**Application reference: EN010115**

### **Five Estuaries Offshore Wind Farm Project**

## Appendix 1: Response to section 51 advice / section 55 observations

DRAWING TITLE:  
**2.11  
 Historic Environment Plan - Onshore**

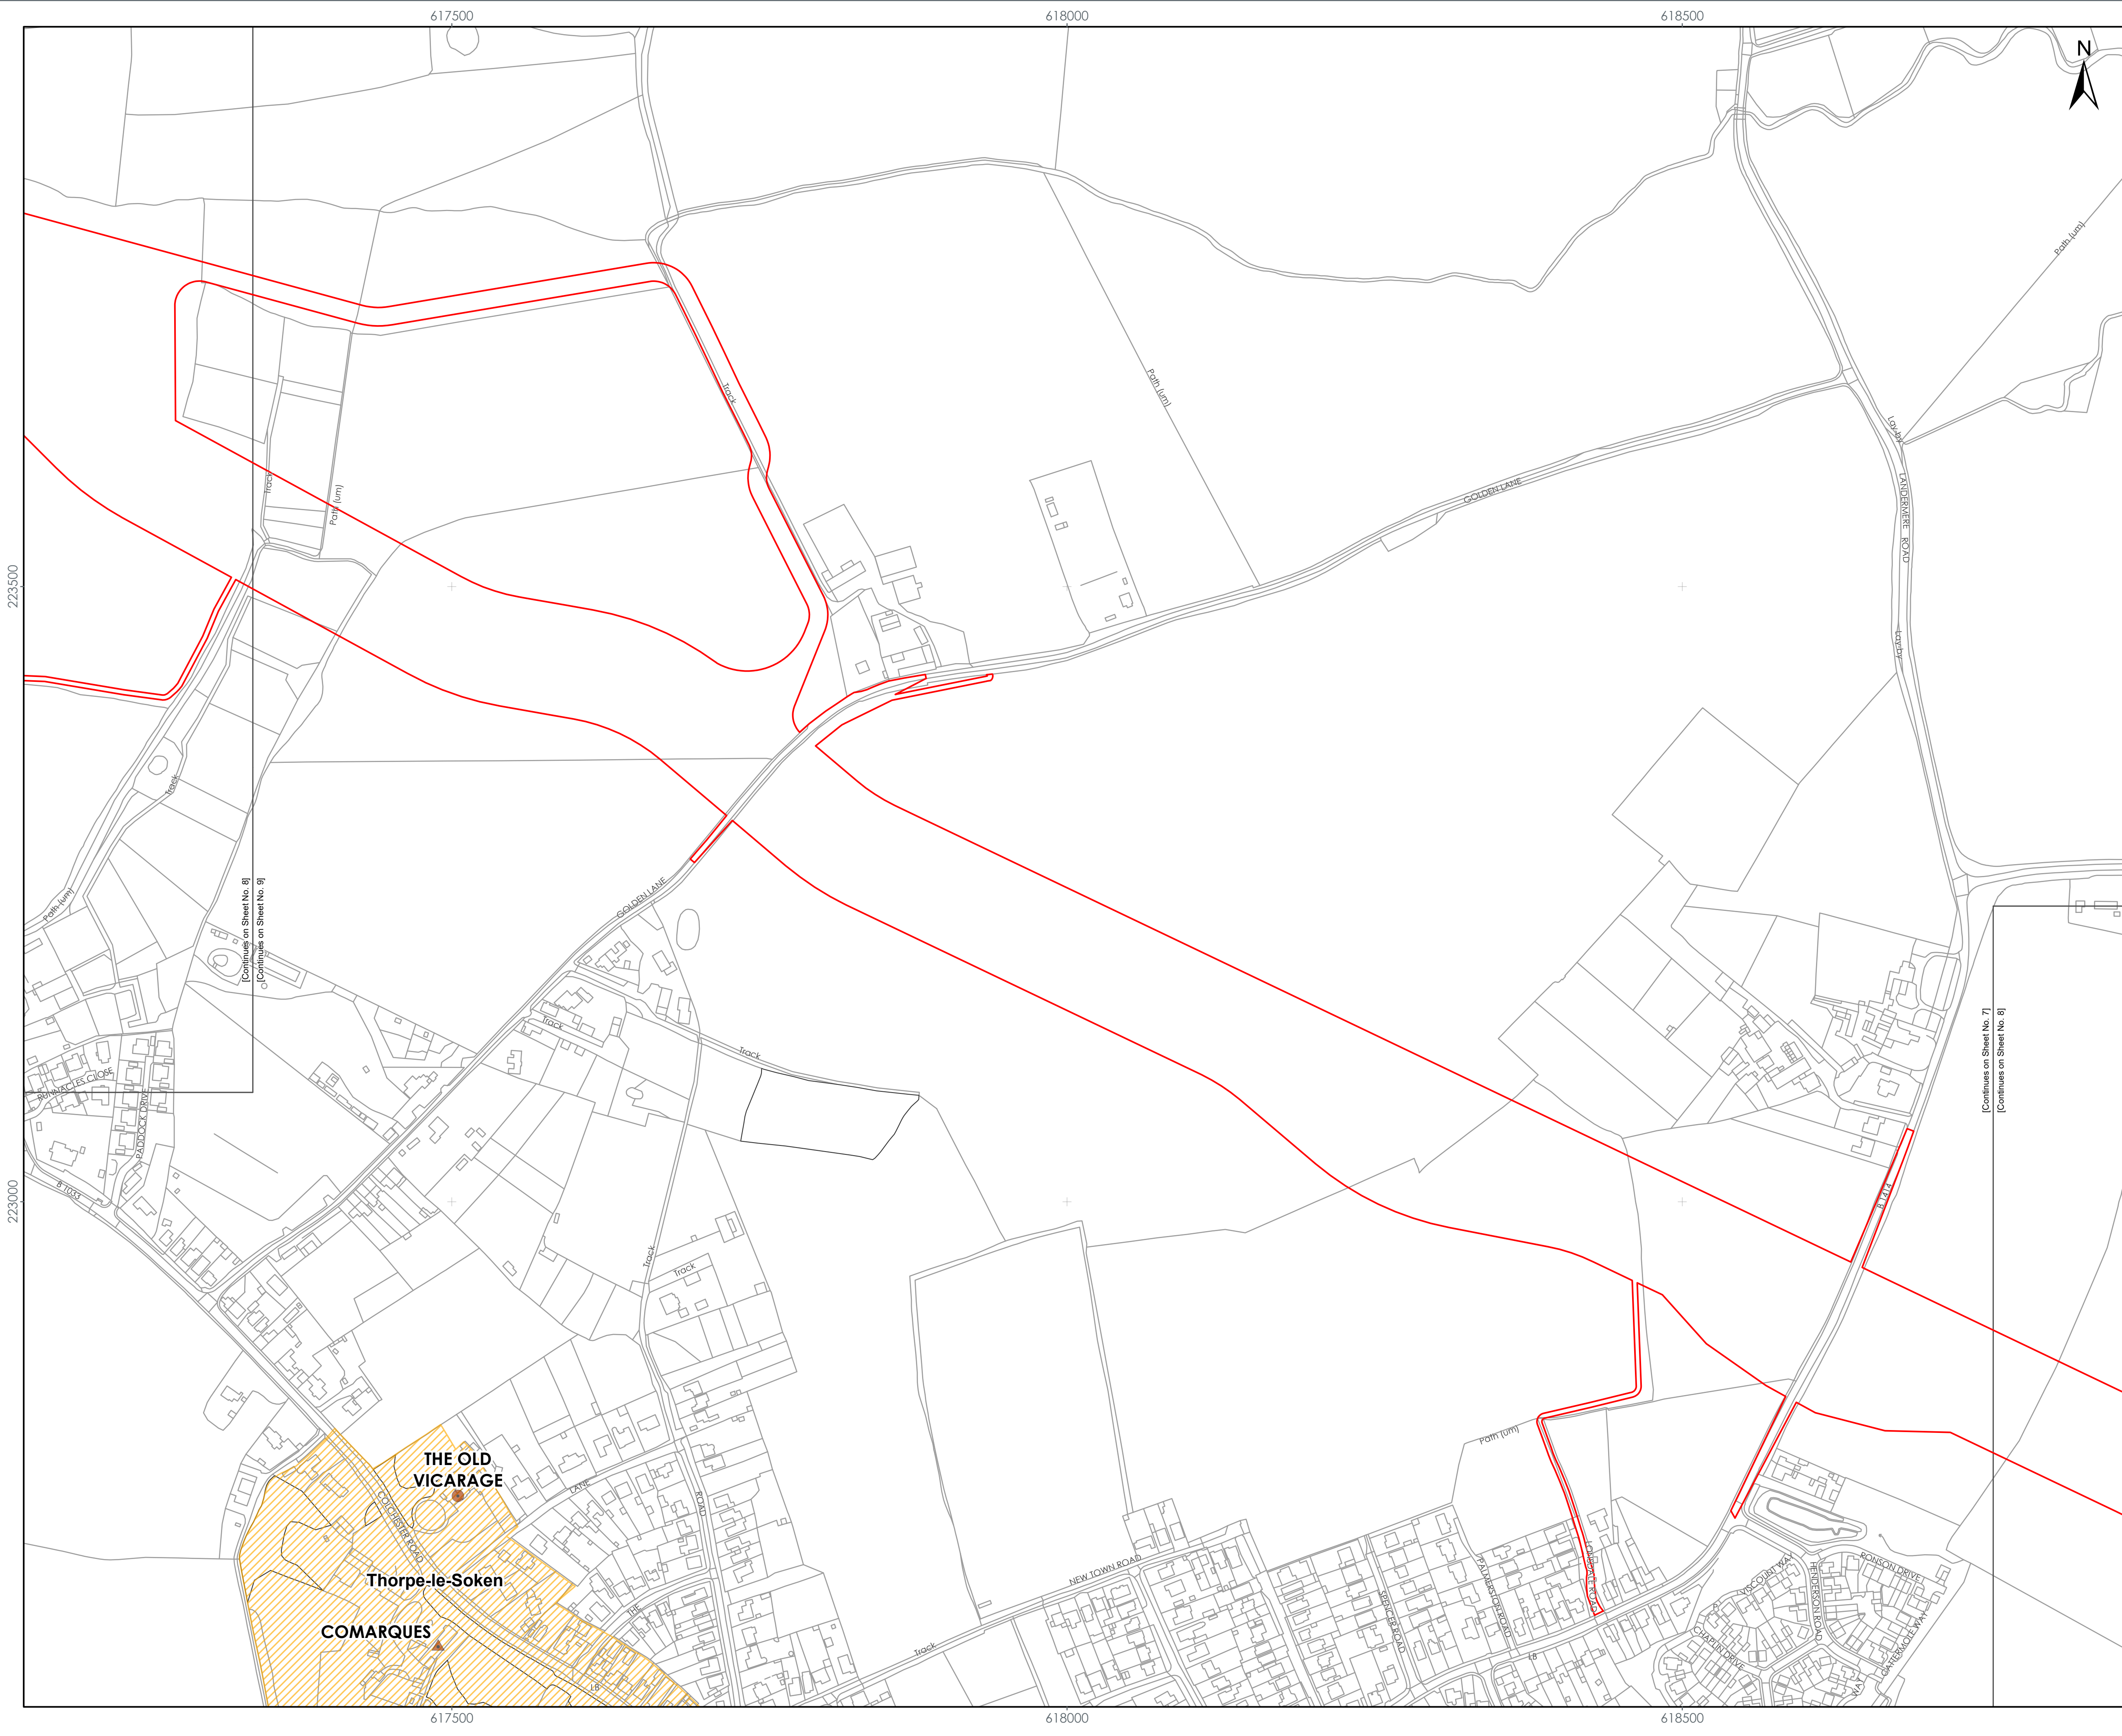
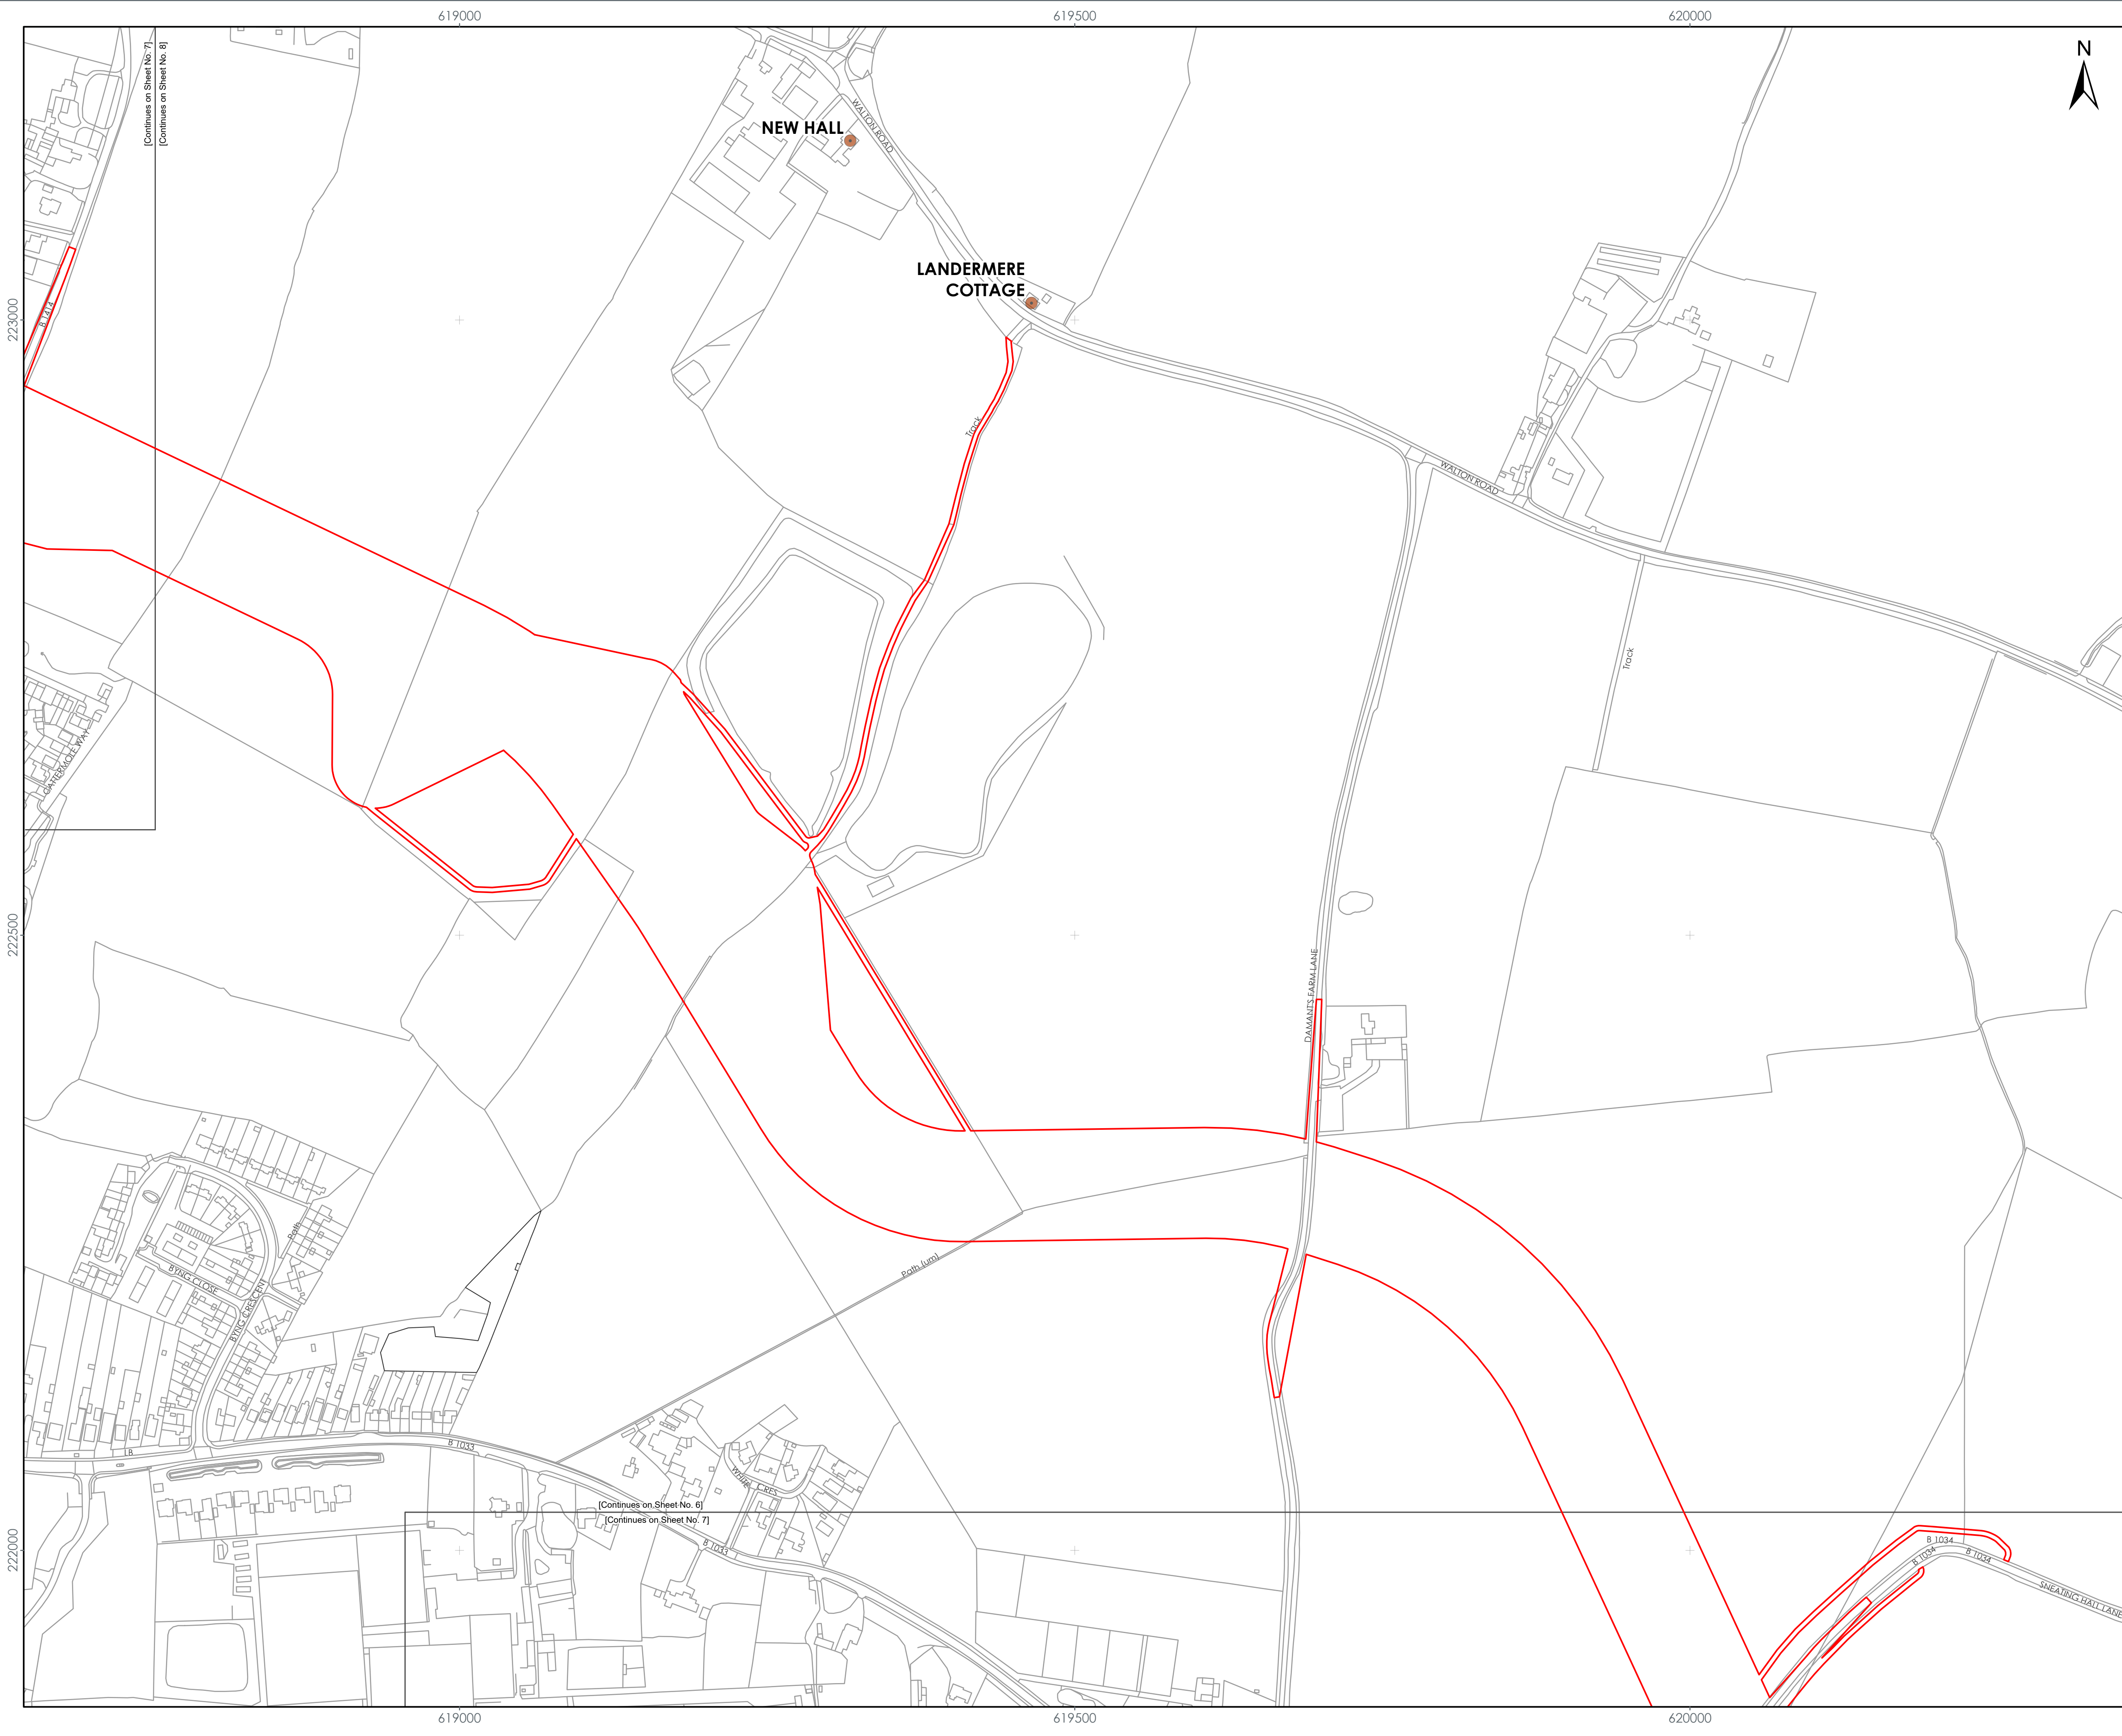
Sheets 1 to 7's are difficult to read due to the resolution being low.	all consistent, rather than having different base mapping.
Historic Environment Plan – Onshore (document reference 2.11)	Historic environment plans show a woodland layer on the key, but this is not visible on the plans. These plans also show ancient woodland which may not be required in the historic environment context and could be included in the Statutory or Non-Statutory Sites and Features of Nature Conservation - Onshore plans (Doc 2.13).	No changes are proposed at this stage as the woodland layer is not key to understanding the plans or a statutory feature.  The project notes that ancient woodland is already included on Statutory or Non-Statutory Sites and Features of Nature Conservation - Onshore plans (document reference 2.13).
Crown Land Plan – Onshore (document reference 2.17)	The colour used for Crown Land in the Legend of Sheet 2 of 2 does not seem to match the colour used on the plan.	No changes are proposed. The land parcel 20-002 shown on Sheet 2 of 2 of the Crown Land Plan – Onshore (document reference 2.17) has land interests from both parties in the key. It is therefore correct as shown.
